From: David Senus <dsenus@woodardcurran.com>
To: Jean Fraser <JF@portlandmaine.gov>
Date: 9/5/2014 5:09 PM
Subject: RE: 2282 Congress Street- Portland ME re MDEP review

They changed the system type back to just a soil filter (instead of a focal point system), which is okay (that is what they proposed back in July). No concerns on my end. It's disappointing that DEP pushed them in that direction, as I believe the focal point provides better treatment. It's just not formally approved by the Department yet in that configuration.

**SECTION B-B**  
SCALE: H: 1" = 20'; V: 1" = 4'

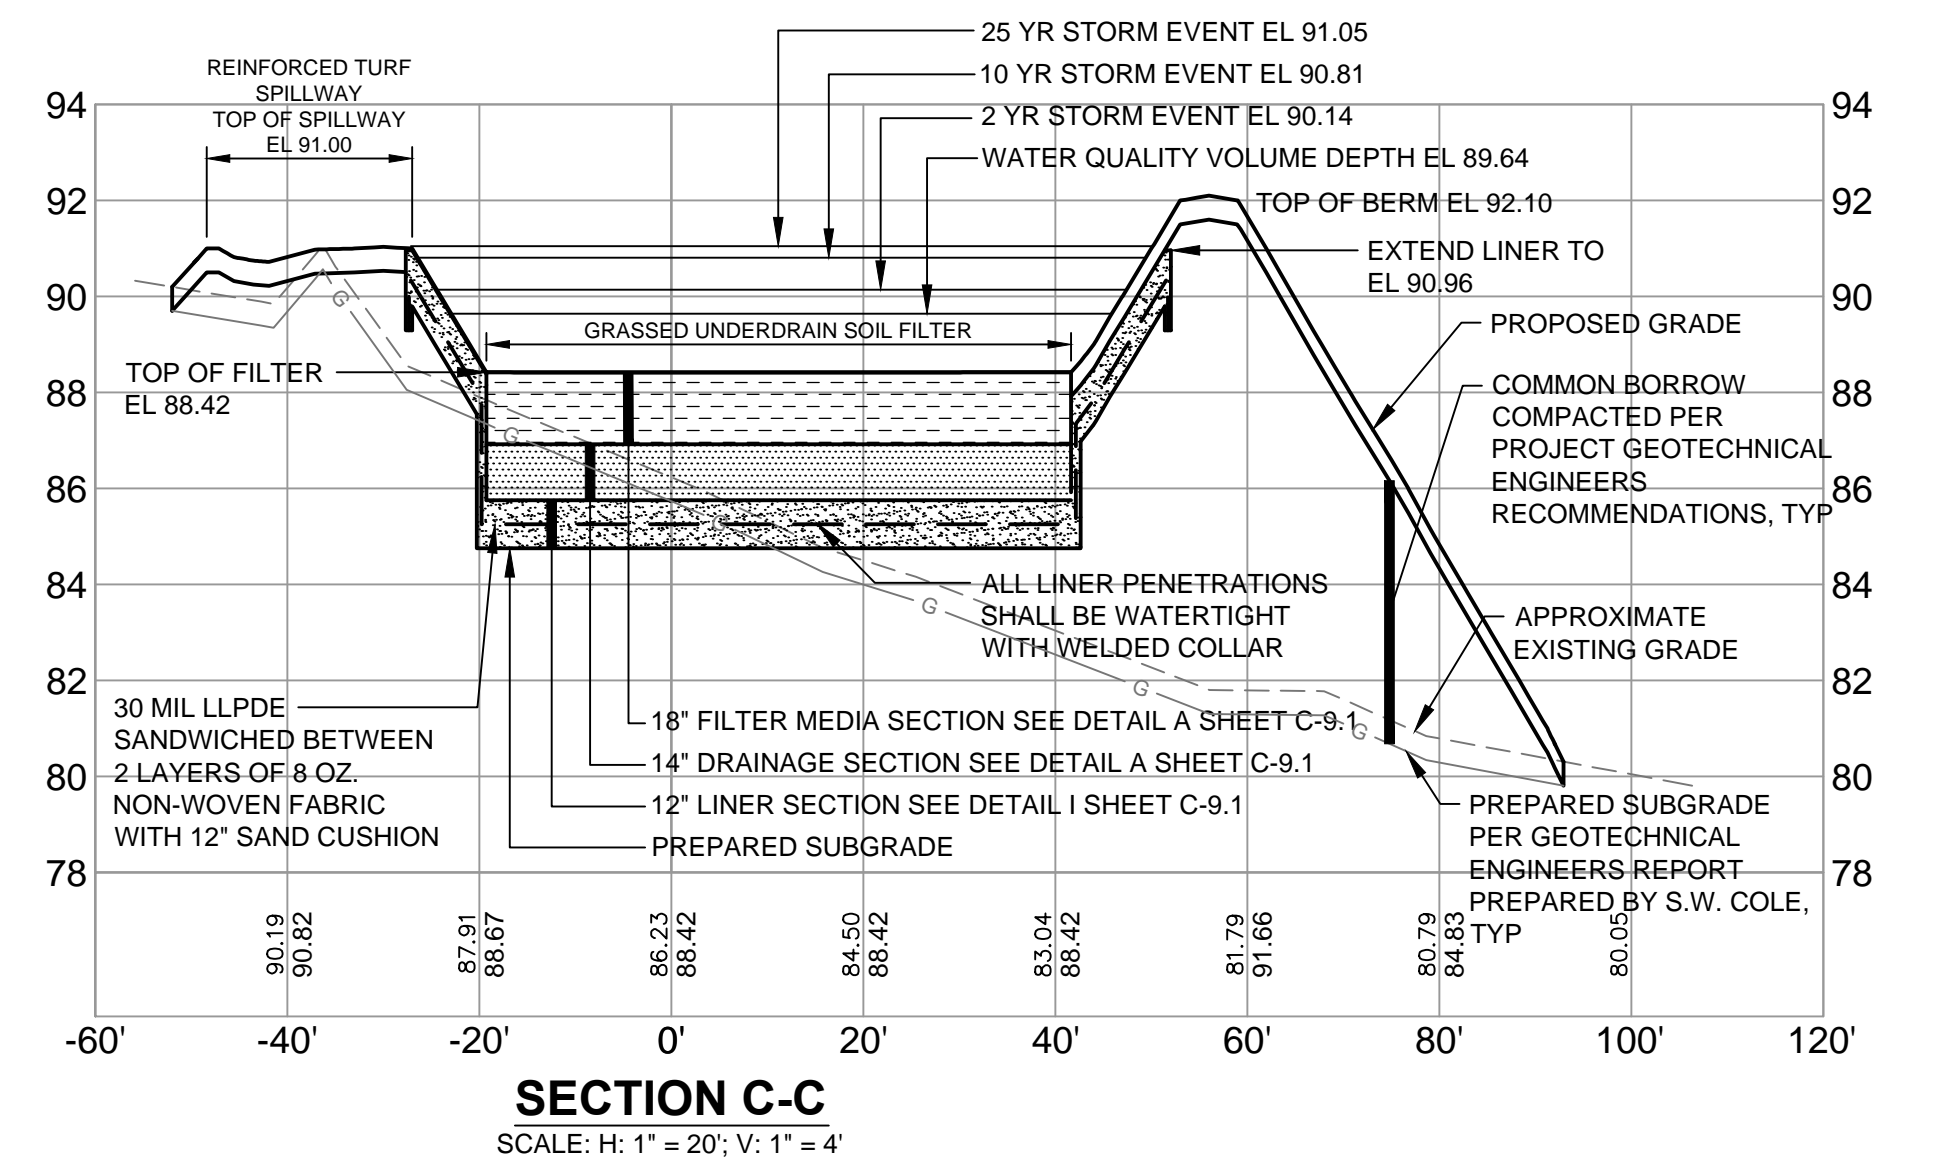
They can plant in the upper areas above the basin. That shouldn't need review by DEP.
